CITY OF ALBUQUERQUE

**Re: Winrock Redevelopment Section 2 and Section 4 Grading and Drainage Plan
Engineer's Stamp Date 7-20-15
Drainage file number (J19D058C)**

A4 ROAD C SECTIONS  
NTS

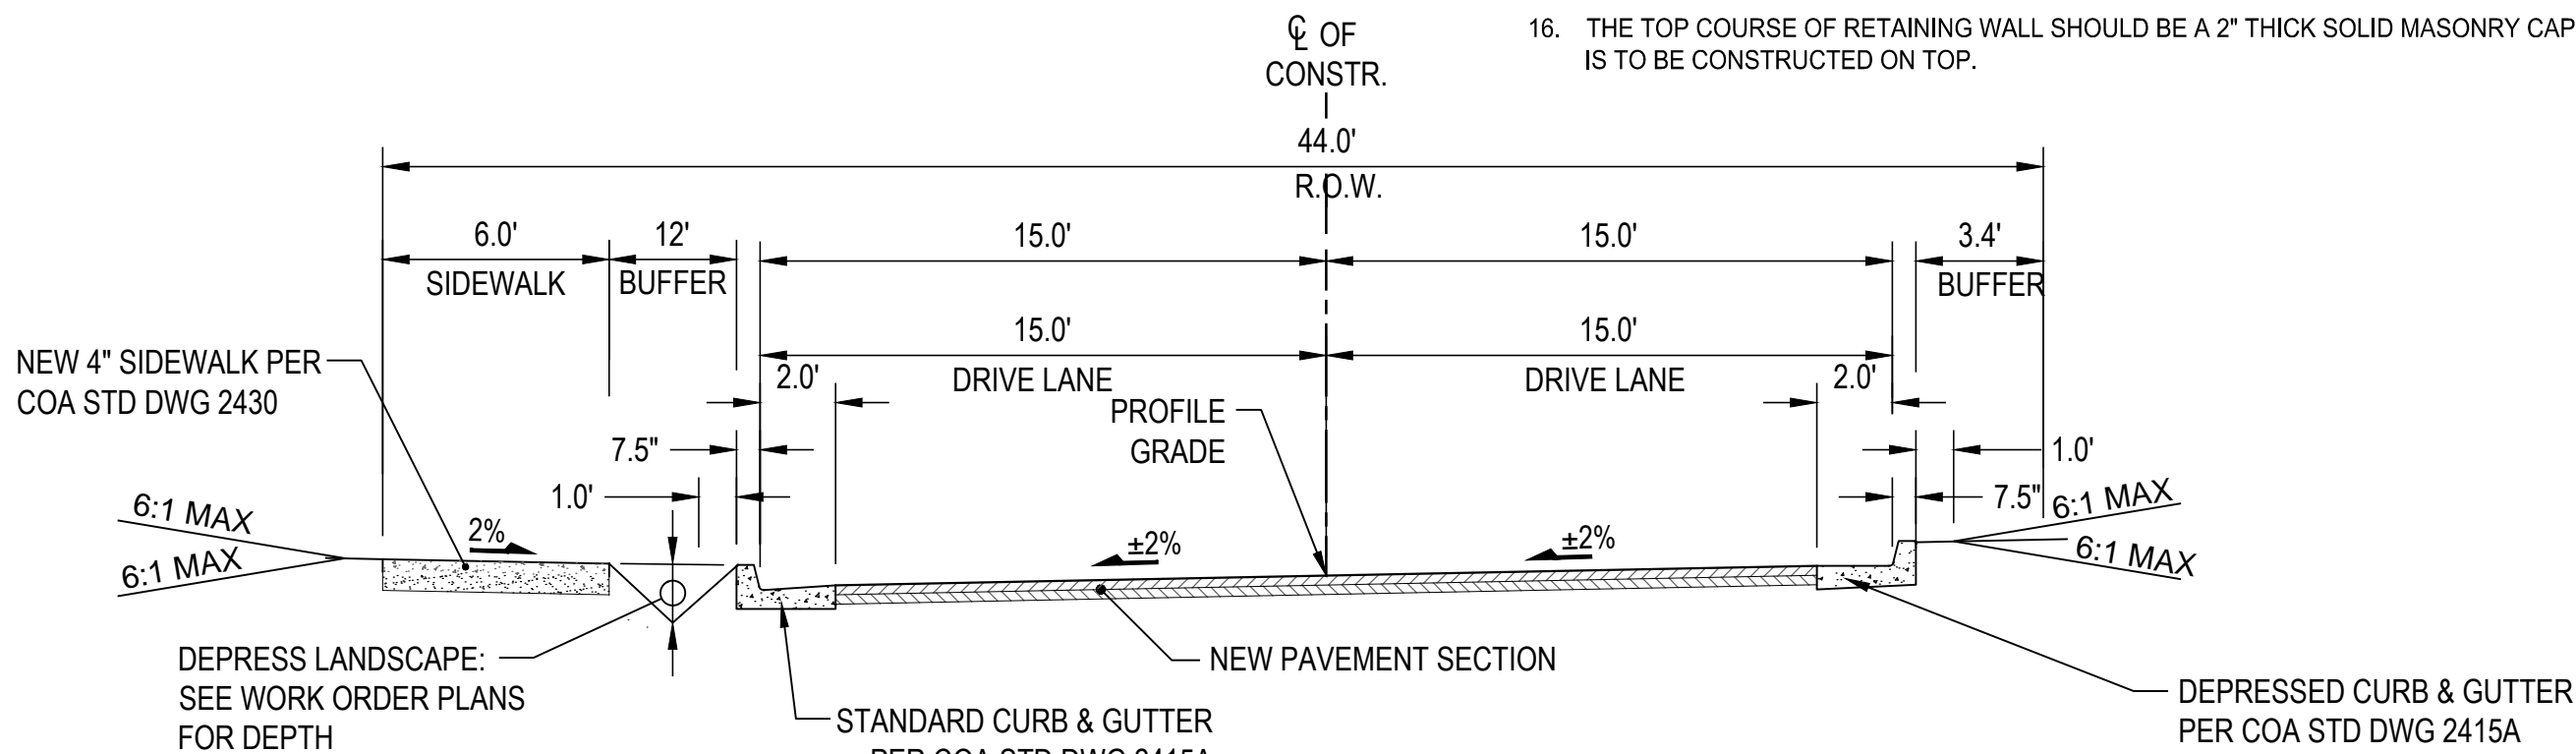
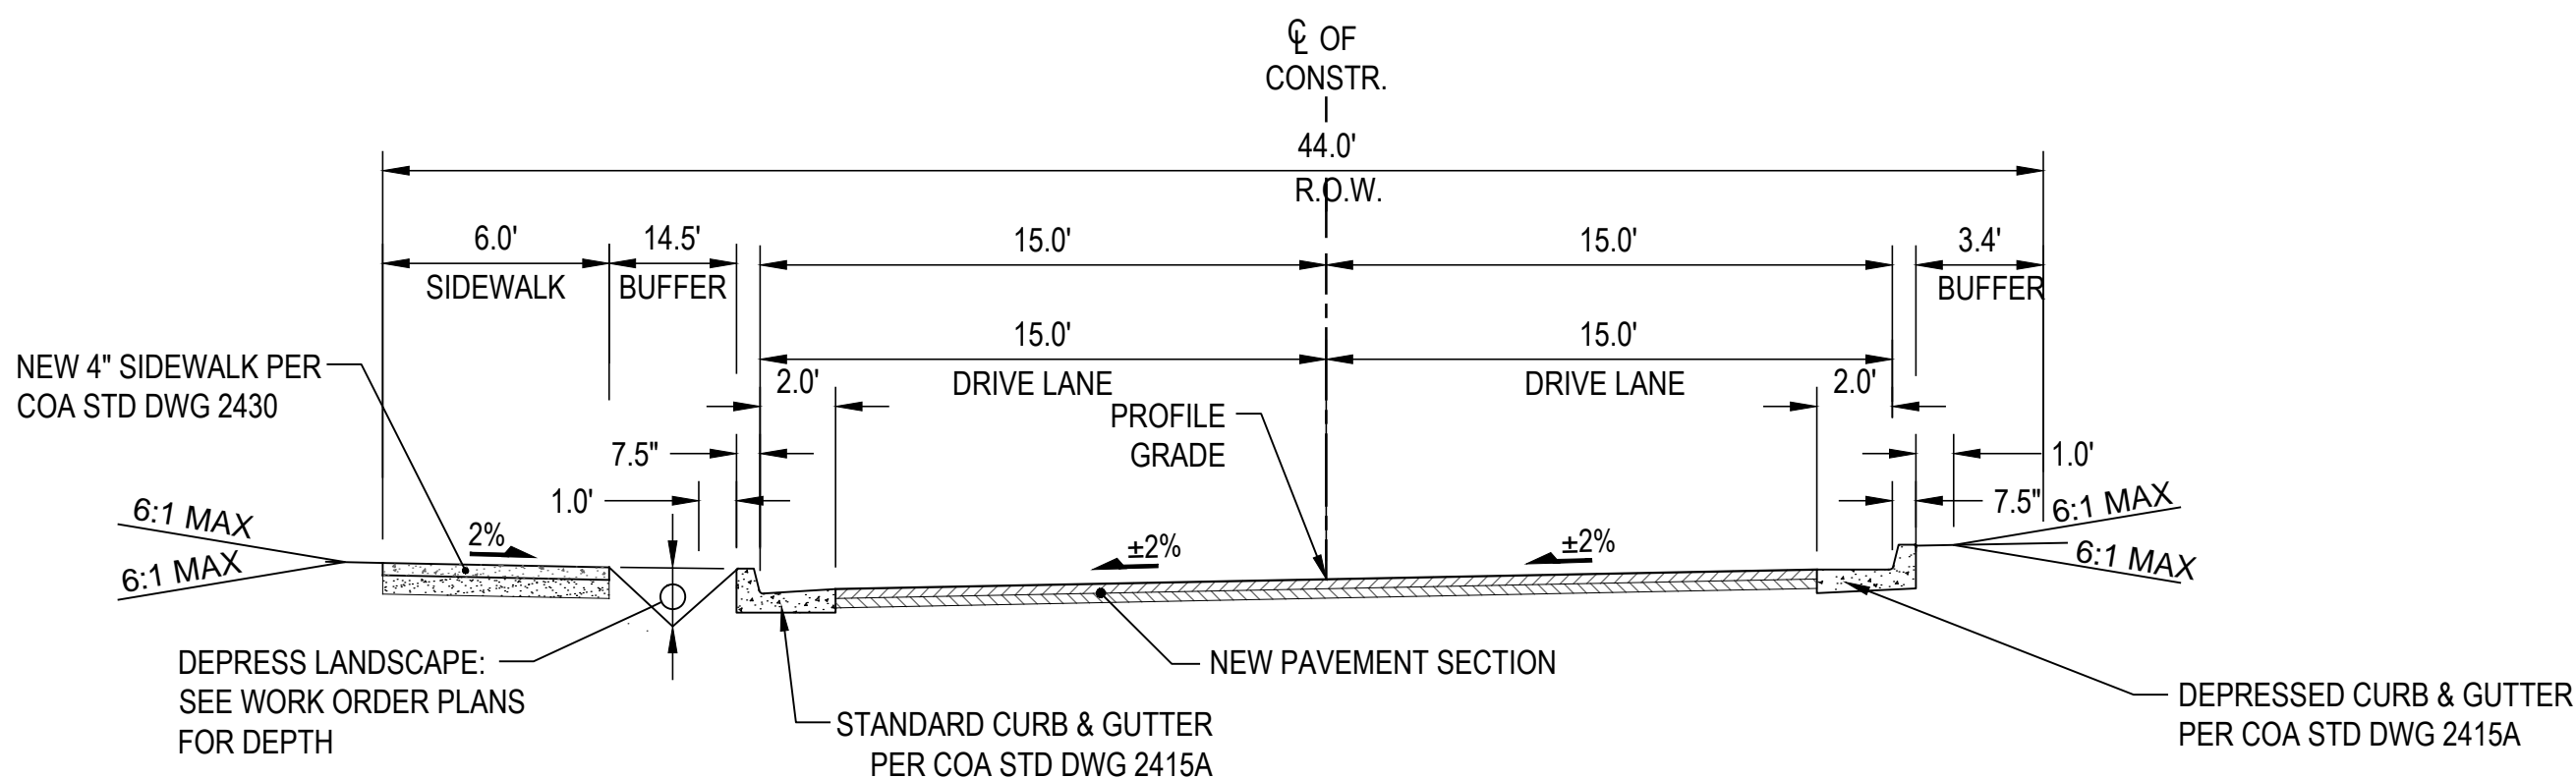
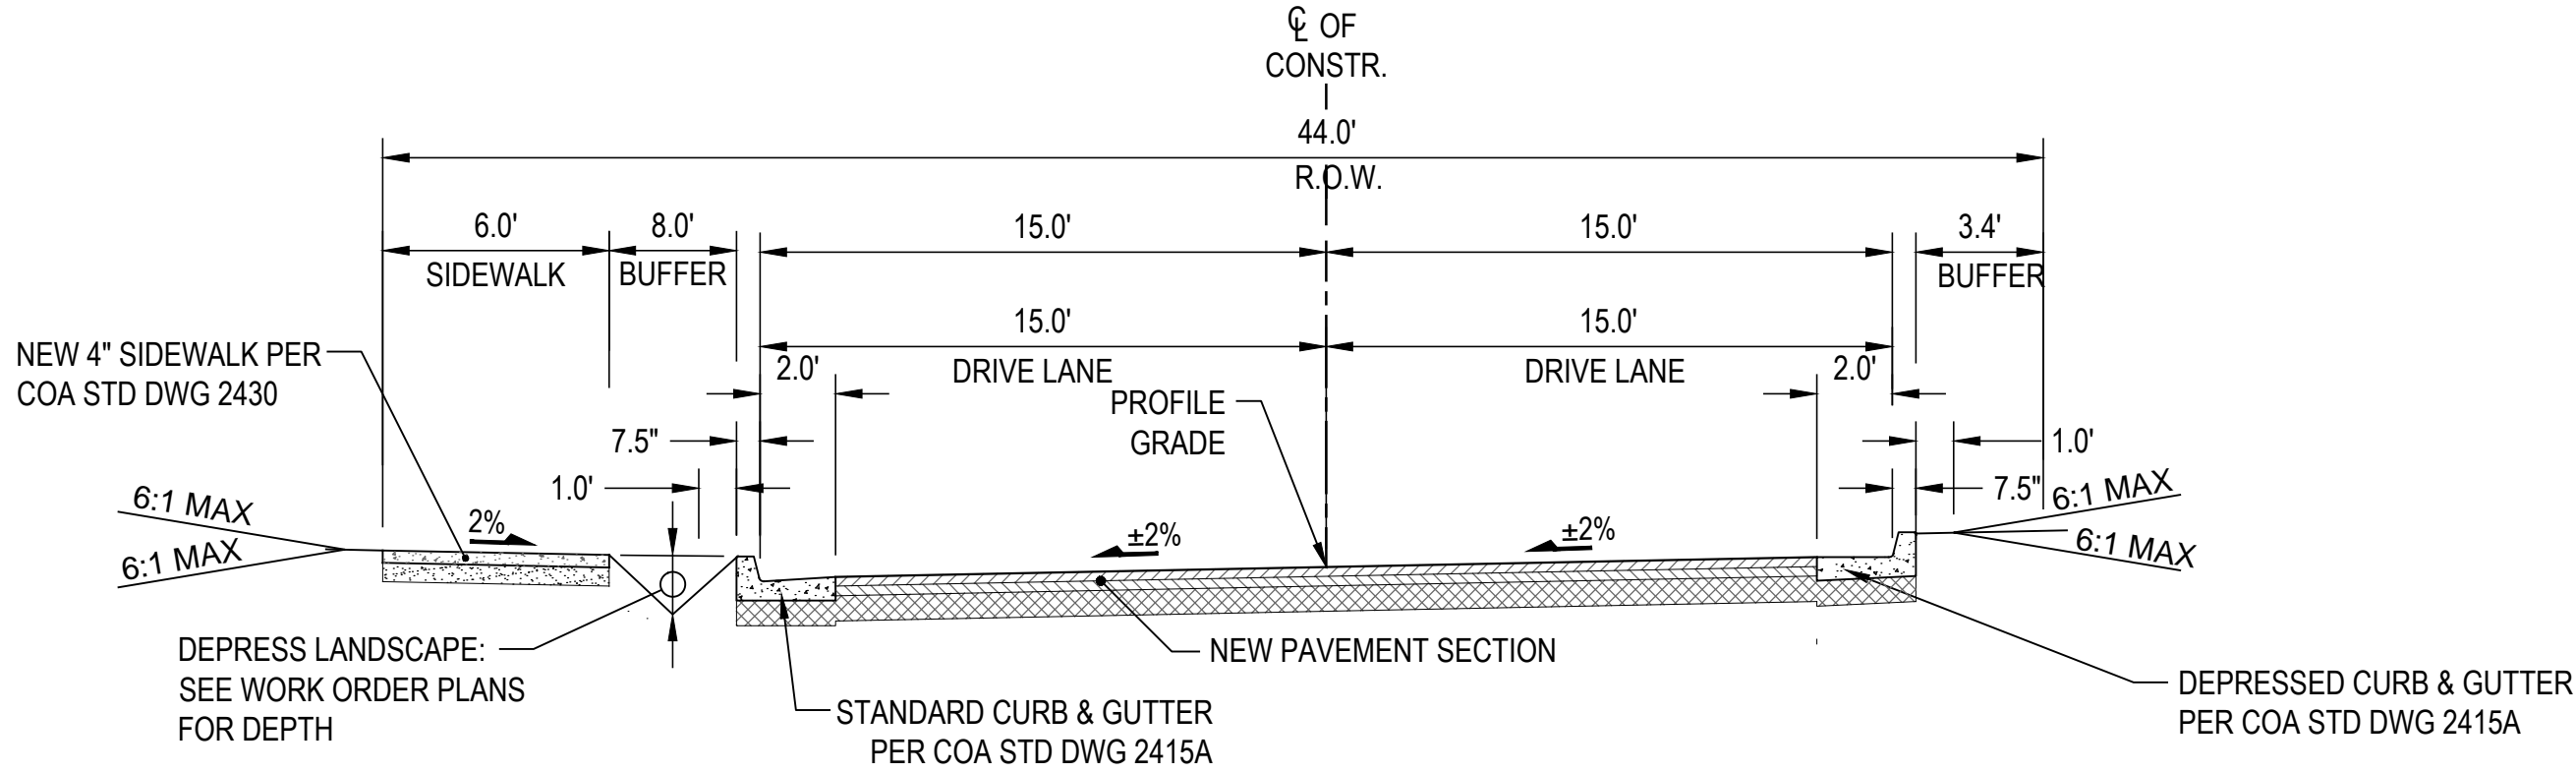
10. The first flush depressed area was inadvertently omitted in Sections A, B, and C on Sheet C505.
